Memorandum

Letter No. 53/1230/92

Sub: OMS - 120 - IV - proposed construction of R+2F commercial building for office purpose at S.O.C. 746 and 148 ^{with the road} in A.S.N. 9685/5, 9686 and 9689 ^{with the road} Chennai - 600 008.
Ref: 1) IFA received in MS No. 462/92 of S.O.C. and S.O. applying for 16/6/92 - 2) P.M. particulars received vide your letter dt. 8.9.92.

SECTION ON AA

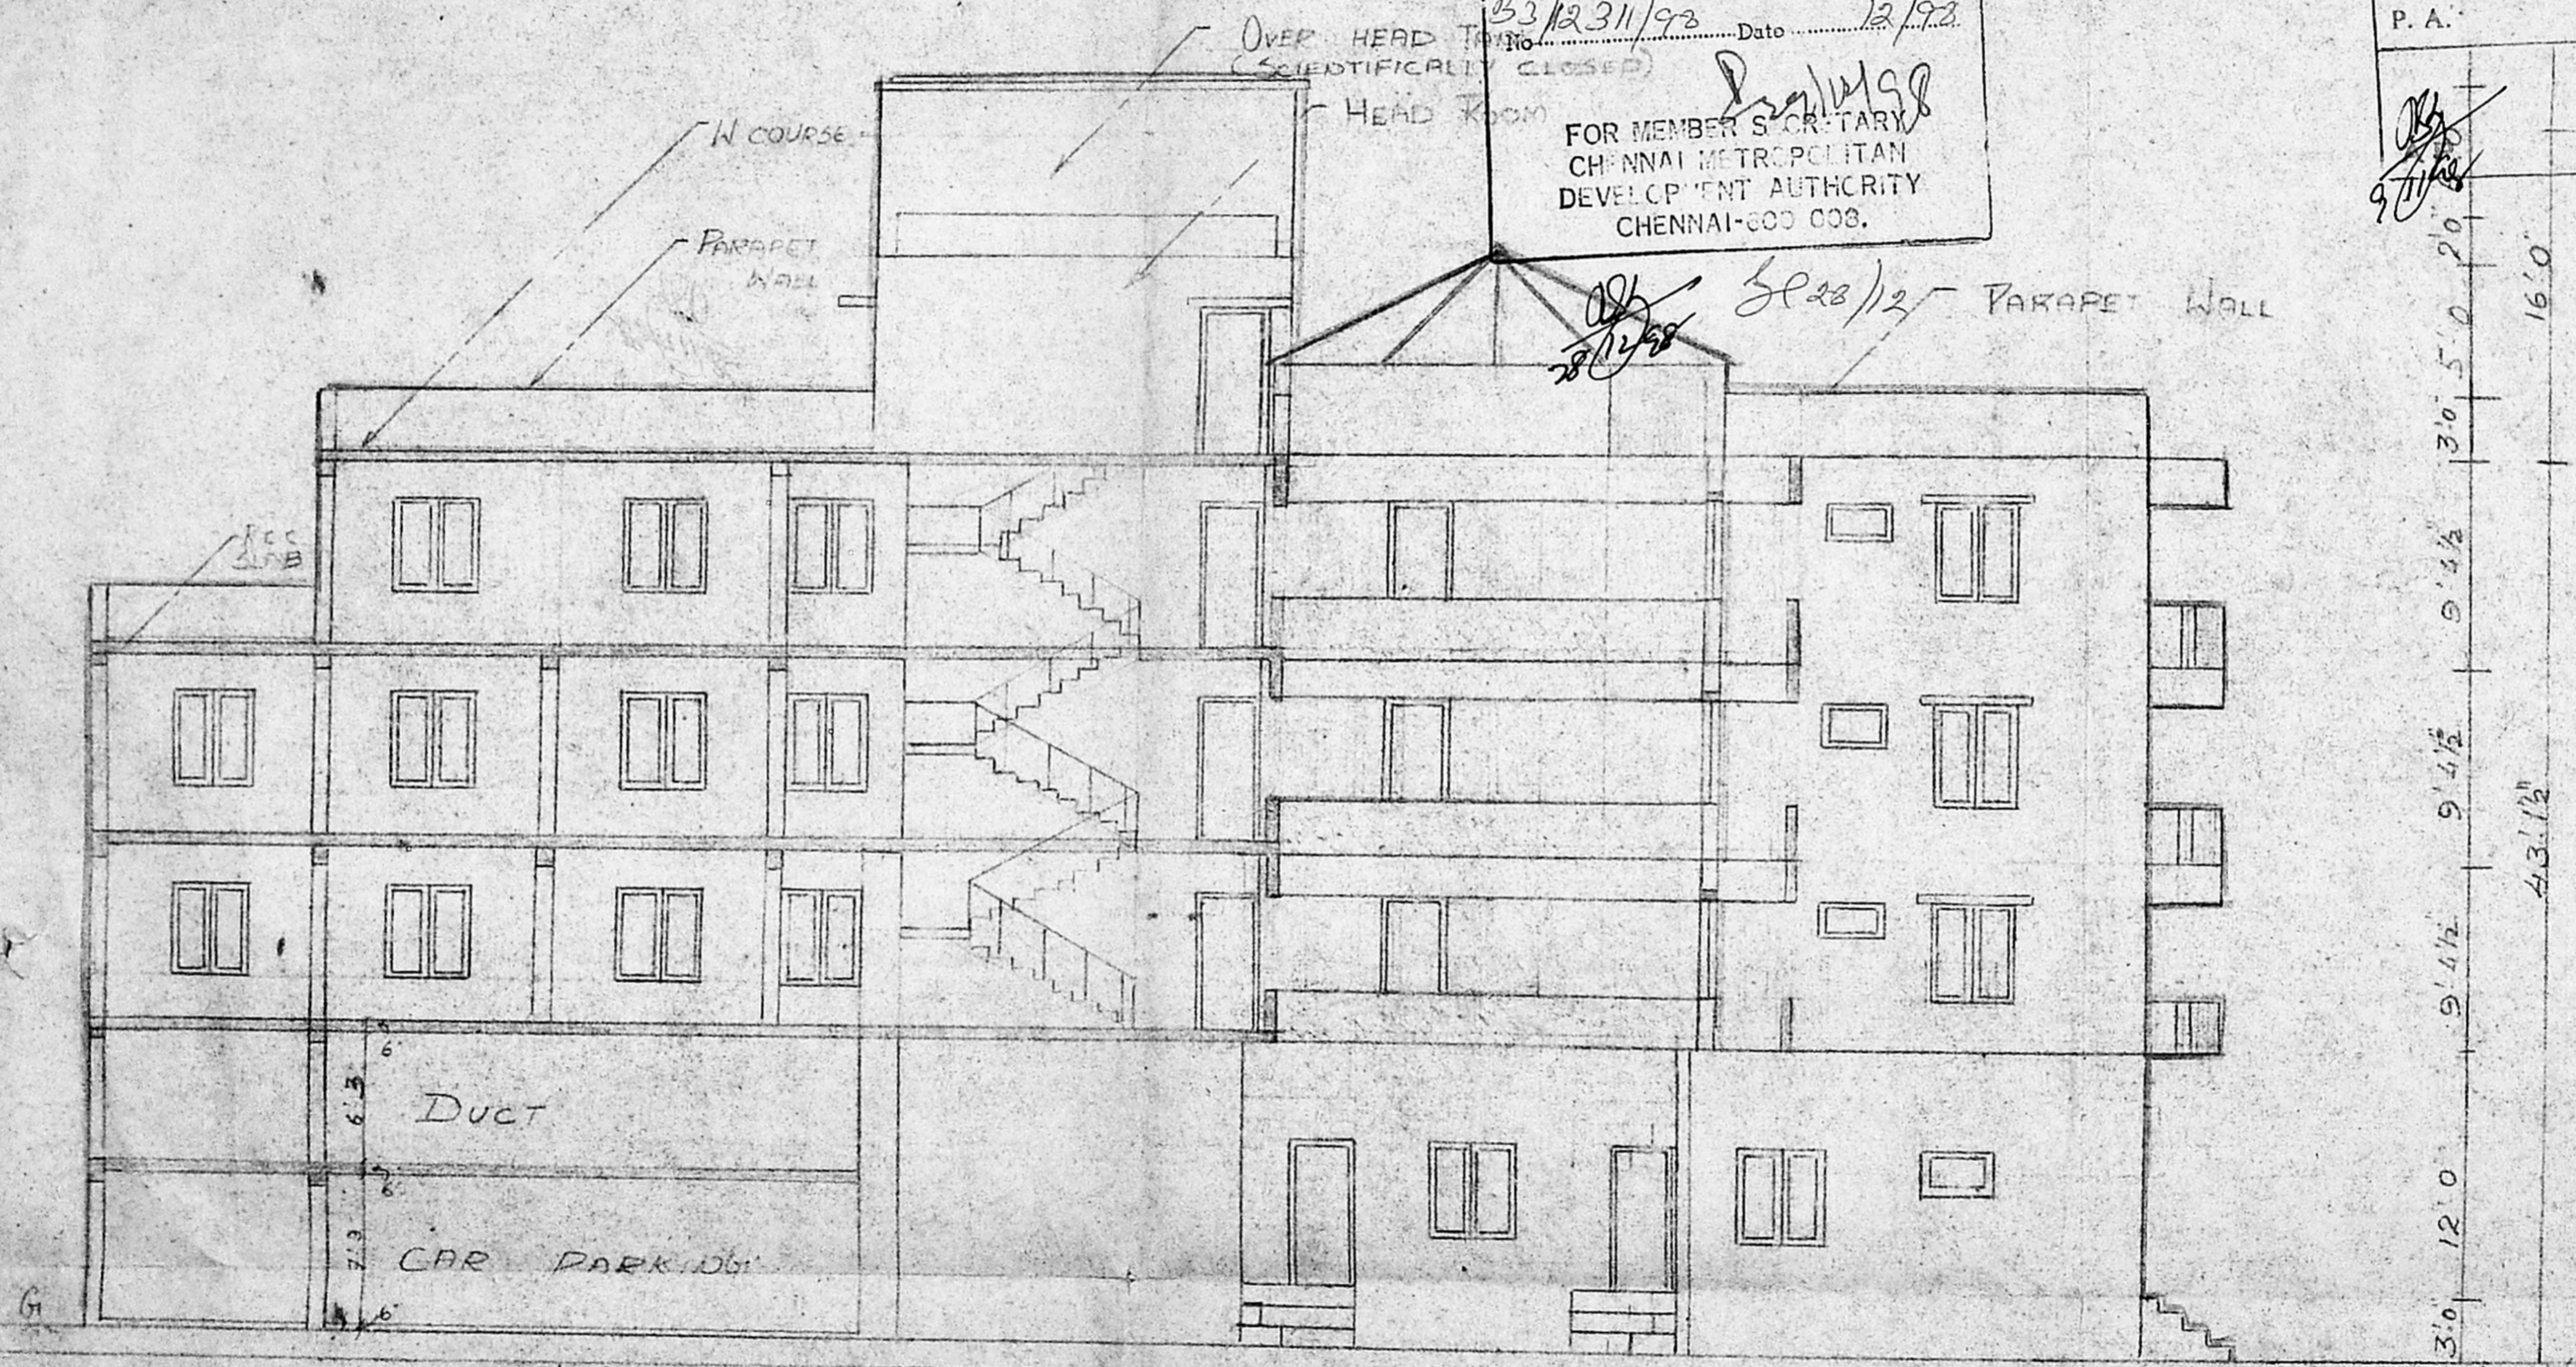
a) you are also reqd to furnish 5 sets of Revised plan showing cross section along the road ^{to be open} and a resolution from the trust to confirm that the signatures ^{of} the lease deed are the trustees of the
